Conservation Area Advisory Committee

Meeting Date : 4th June 2018

CROSS-SECTION OF SHEDS

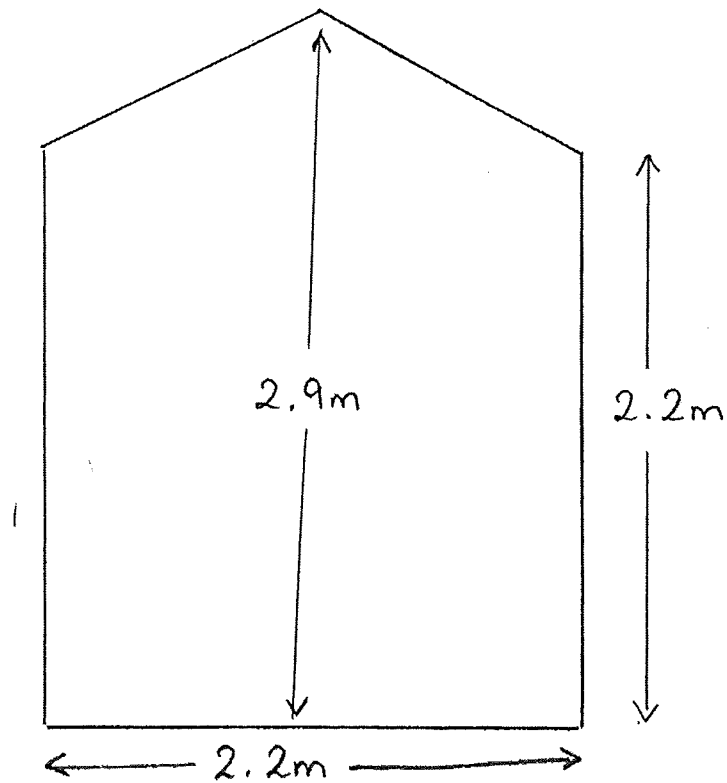
Ref	Description	Address	Design award
<u>LU/65/18/L</u>	Listed Building Consent for the repair & restoration of slate tiled roof of outbuilding. Replacement of flat, felt roof on old outhouse with slate tiled roof, to match adjoining outbuilding	5 River Road Littlehampton BN17 5BN	
Comments: <u>OBJECT</u> Suggested Conditions: <u>MUCH MORE DETAIL IS REQUIRED INCLUDING EAVES AND VERGE DETAIL. EXACT SPECIMENS OF TYPE OF SLATE TO BE SUBMITTED.</u>
